2023/0184

Demolition of existing dilapidated barn and construction of replacement detached two storey dwellinghouse with associated parking and garden areas

Ivy House Farm, Chapel Road, Pilley, Barnsley, S75 3AR

Site Plan 1:200

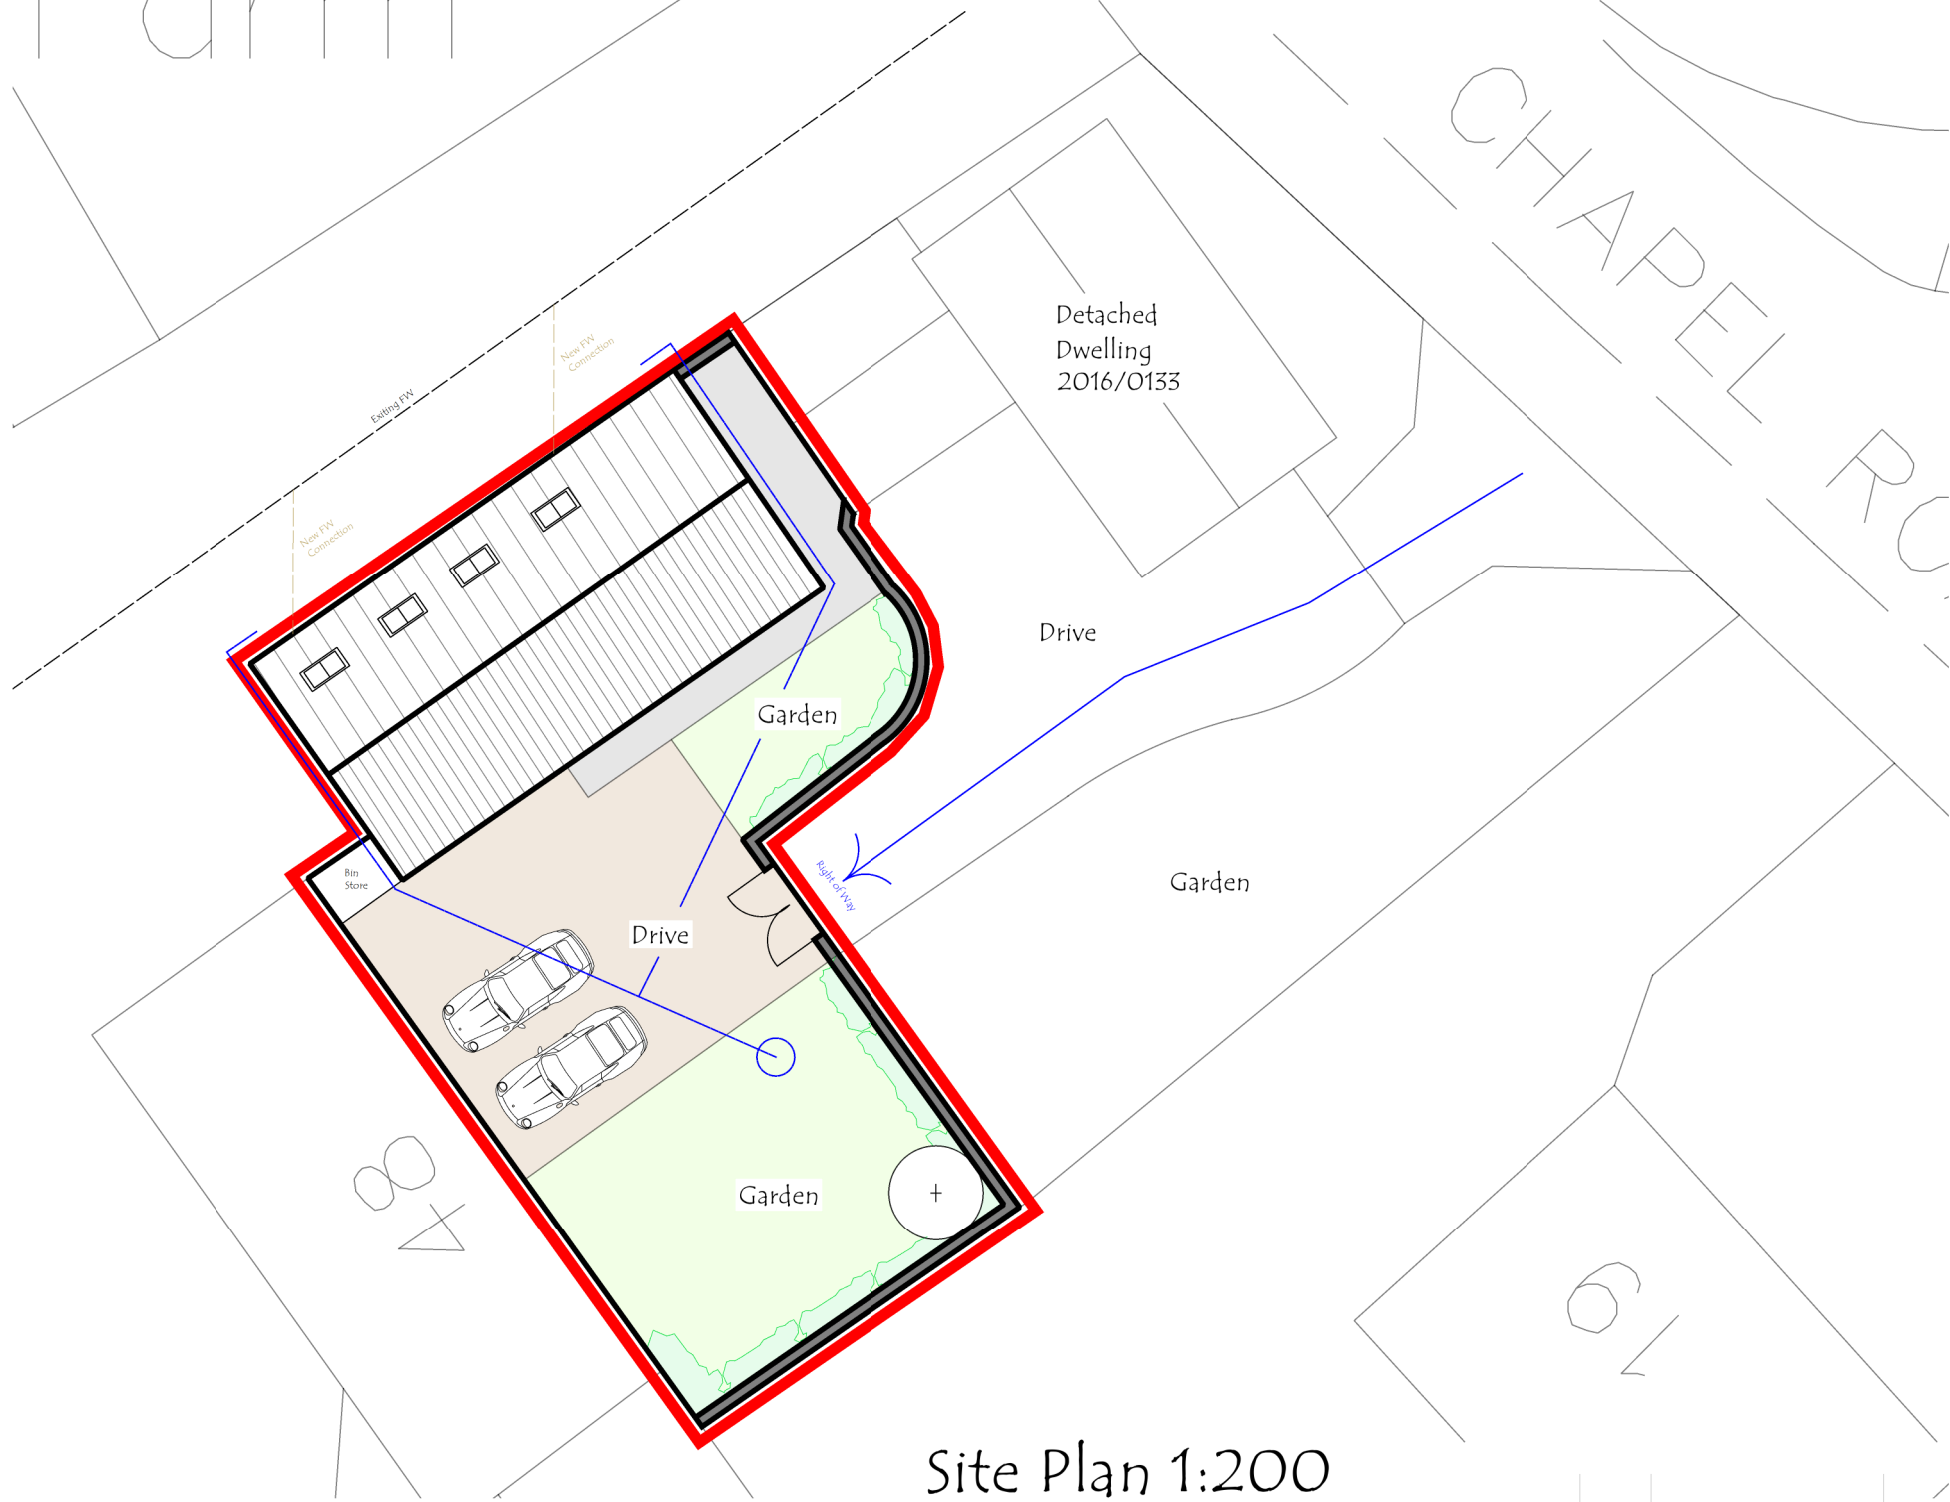
Highways DC – Initially stated that the proposed access would need widening to a minimum of 4.5m as it would serve more than one property. There are also no bin storage or collection pads shown on the plan; these should be demonstrated for both the host and proposed dwelling. The original application also included a gate across the driveway which would have to be removed to allow separate access to two or more dwellings. Upon receipt of the amended plan showing the above recommendations, no objection was raised to the development subject to conditions and an informative.

Colleagues in Highways DC were consulted on the proposal and requested some alterations to the width of the proposed access. The agent submitted an amended plan which increased the width of the access and Highways DC did not object subject to conditions and an informative.

Proposed Front Elevation

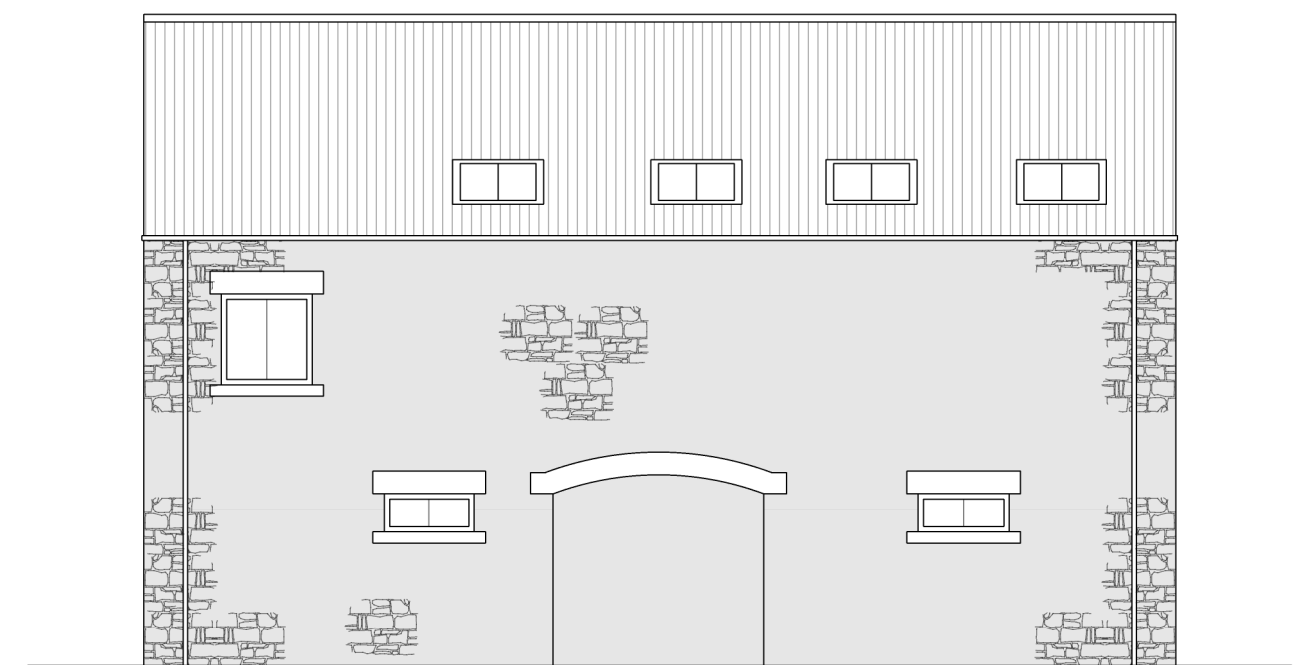
Initial response – Provided a lengthy pre-application response to the scheme and pointed out the need for (amongst other things) a heritage impact assessment. The agent provided the HIA and on balance, it is agreed that the proposal could be justified in principle. However, we would ordinarily require an engineers report setting out the structural condition which precludes the ability of the building to be conserved and repaired. In relation to the proposed design, it is welcomed that the development includes the replication of the overall envelope of the existing building, its general form, massing and scale and in general, it is felt the design is appropriate. The inclusion of the blind inset cart openings that echo the original barn are also a welcome addition. However, the windows have been discussed previously and they are very numerous and regimented in arrangement and lend a distinctly domestic appearance to the proposal. This could be easily avoided by including differing sizes and arranging these openings in a more organic (less organised) fashion. Some glazed ventilation slits could also add a vernacular feel to the elevation. This is important because as I have maintained from the outset, the proposal site is within the setting of the grade II Manor House, so there is a need to be deferential and sympathetic to its significance. I also note the suggestion that the glazing may be UPVC. I would object to this and advise metal framed windows and doors would be much superior in this setting.

Second response (to amended design) – The organisation and appearance of the windows are an improvement and support is raised for the amended design. However, a condition is recommended for further details in regard to the window design/materials.

The proposed dwelling is the exact same dimensions as the building it replaces, and the external fenestration details on request of the Conservation Officer have been amended to retain the original character of the building. Notably there are 2 x blind inset cart openings on the front and rear elevations which are welcomed to retain the agricultural character of the building/area. The window heads and cills are stone, again which seek to replicate the existing building. The building will be constructed from external materials which will relate well to the existing surrounding area and a condition will be attached which requires the developer to submit samples and/or exact specifications prior to development commencing. Generally, the proposed development has clearly been designed to replicate the existing arrangement and design of the building and is considered to be acceptable. However, the Conservation Officer has requested further details in regard to the window design/specifications and external materials. Both of these elements will be covered through a planning condition.

The application site is a barn which is attached to a listed building – The Old Manor House, 48 Chapel Road – which is an early C18 Century farmhouse. The Conservation officer has been consulted on the proposal and requested some alterations to the external fenestration of the building. An amended plan was submitted which made the changes requested by the Conservation Officer who raised no objection to the amended design.

- 3 Upon commencement of development details of the proposed external materials and window details/specifications shall be submitted to and approved in writing by the Local Planning Authority. The development shall be carried out in accordance with the approved details.
Reason: In the interests of the visual amenities of the locality and in accordance with Local Plan Policy D1 High Quality Design and Place Making.
